Subject: FG/46/20/PL

The Tudor Close Public House, Ferringham Lane, Ferring, BN12 5NQ.

Conversion of the existing Public House (Class A4) to create 7 No residential units comprising 5 No 1-bedroom units & 2 No 2-bedroom units & the erection of 2 No 2-bedroom semi-detached chalet bungalows with associated car parking & landscaping. This application may affect a Public Right of Way

Drawing Title:
Elevations
As Proposed

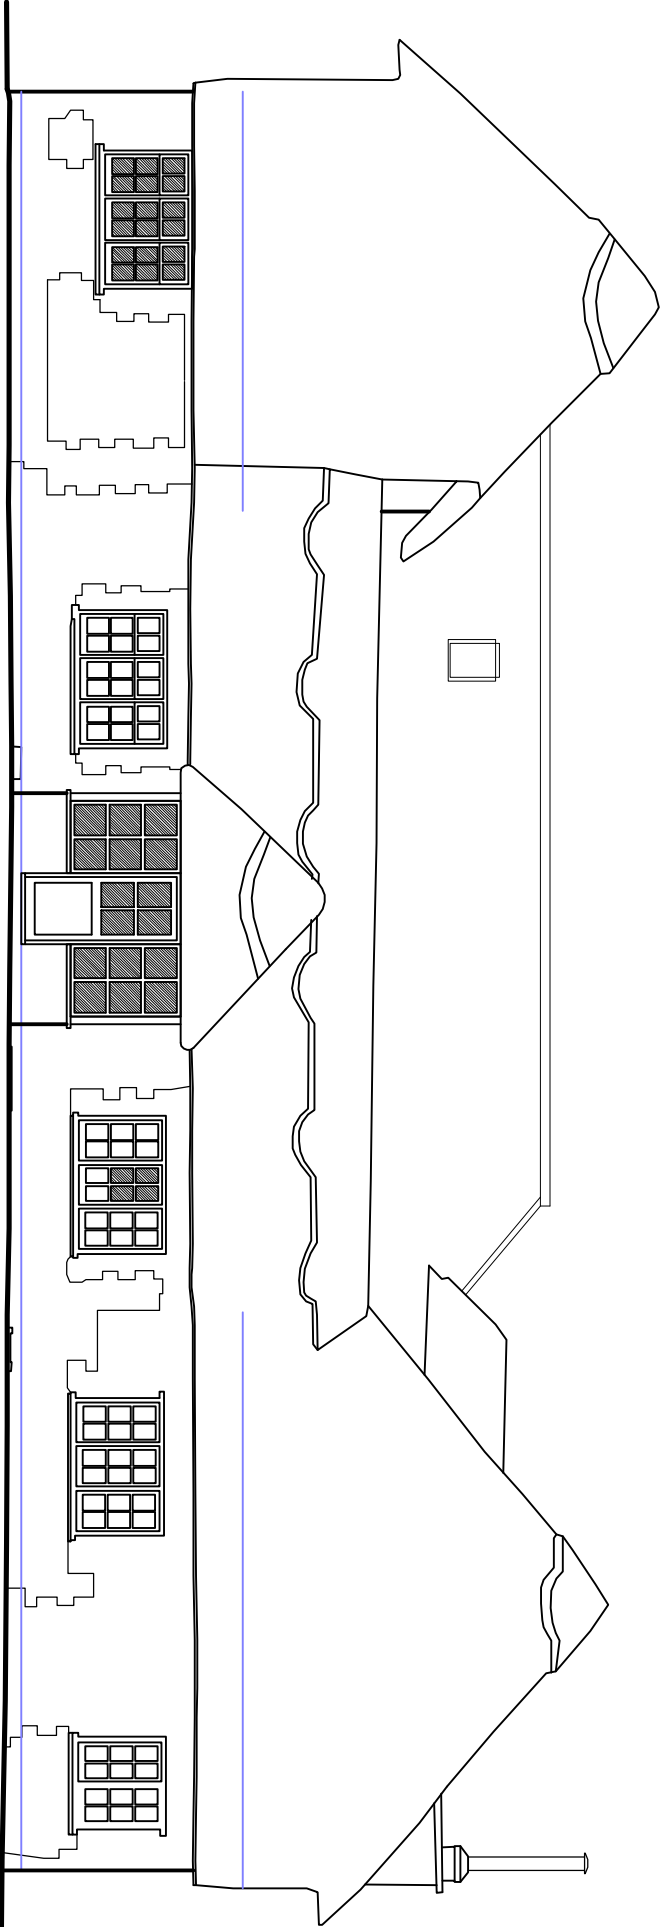
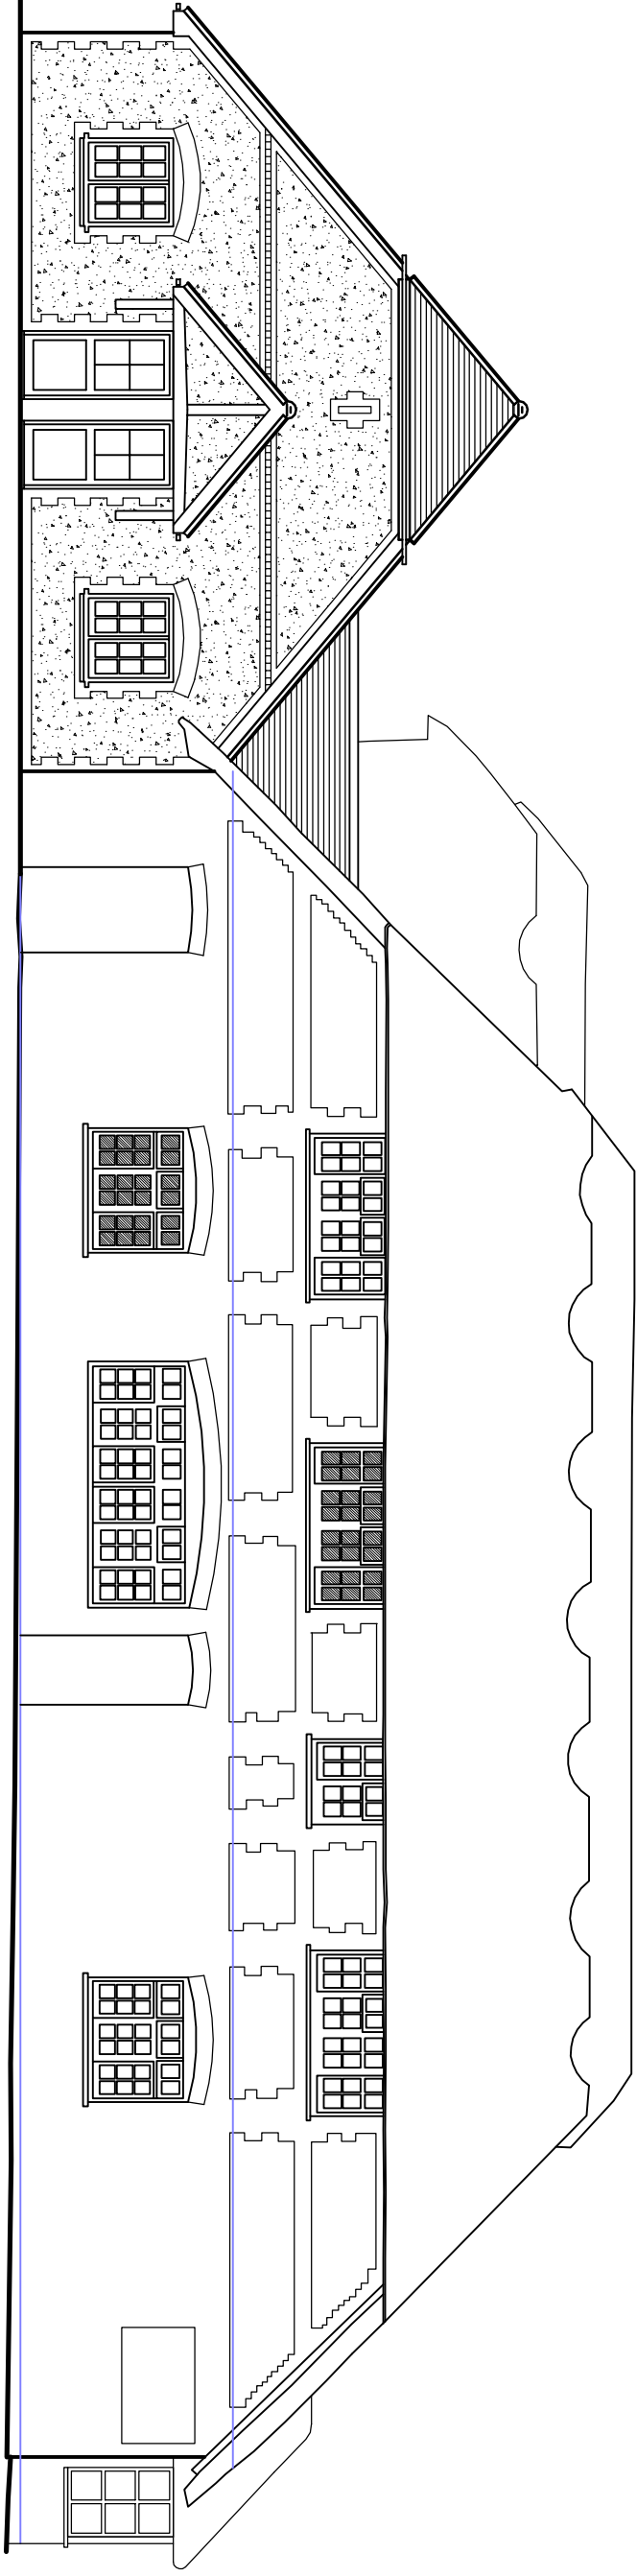
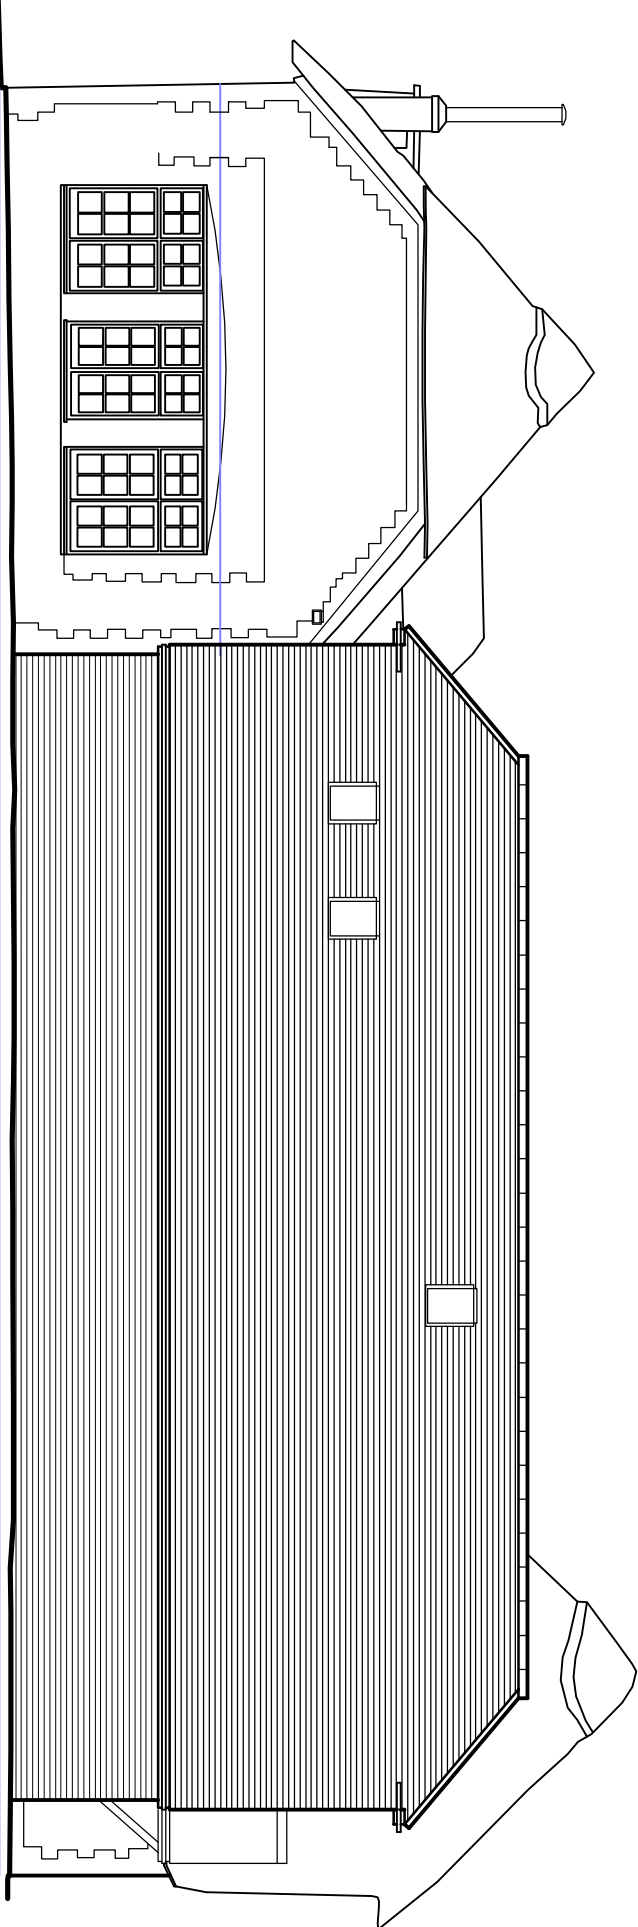
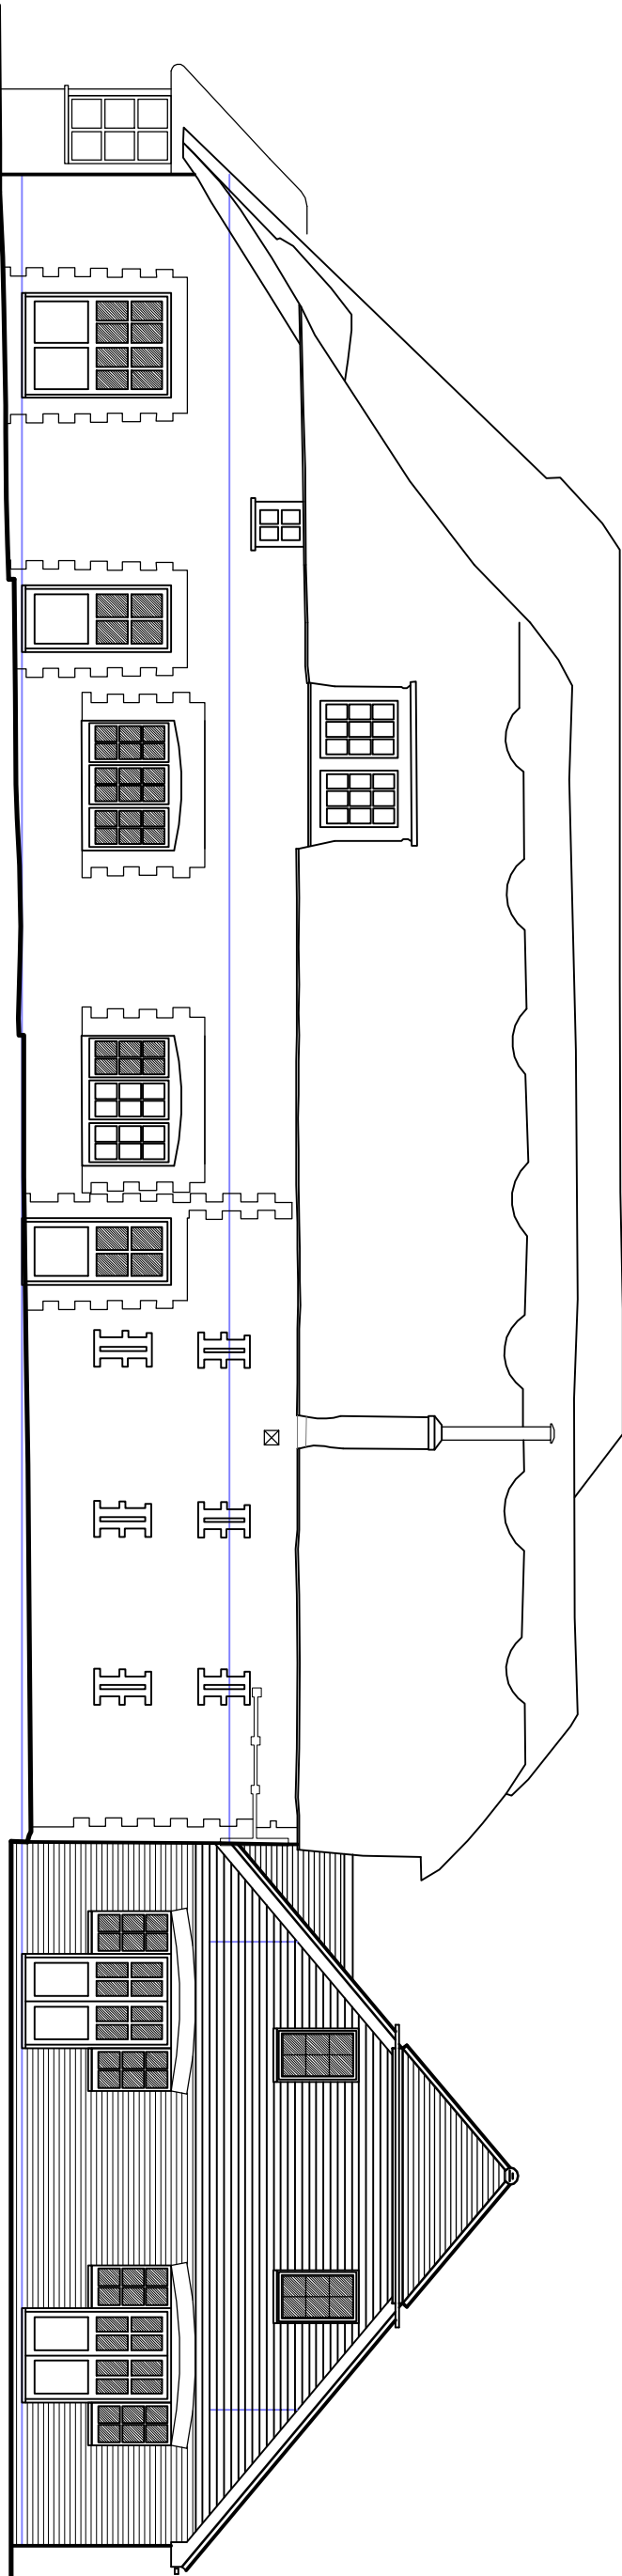
Alterations to the northern elevation of the building which include the removal of a door and windows and the installation of windows and a new porch will not harm the appearance of the building, subject to the design and materials of the joinery.

The removal of the north-western element of the building which consists of a later, flat-roof extension is a positive alteration as it is considered to be of poor architectural merit and will improve the appearance of this part of the building. It is noted that new doors and windows are proposed on this elevation as well.

It is also not clear if any other windows on the existing building and doors will be replaced as part of the proposals. As a consequence, it is recommended that all new windows should be of traditional design and materials to reflect the character of the building.

The two new semi-detached chalet bungalows would be located towards the rear of the building in a style somewhat similar to the existing building. However, they are considered to be problematic and not suitable for the host building. The new bungalows are large and would accommodate a large area of the remaining rear garden space.

The location of the building would be such that it alters the simple southern elevation and leave a large area of what appears to be a blank brick wall and tiled roof. This creates an unattractive elevation which then competes with the remaining visible element of the existing elevation.

It is also considered that even though they are located on the southern elevation of the building that they are of a size which would mean that the roof would be visible from the north of the site and the street.

Further, the point where the existing eastern elevation and the new bungalows meet is clumsy and does not have a positive impact.
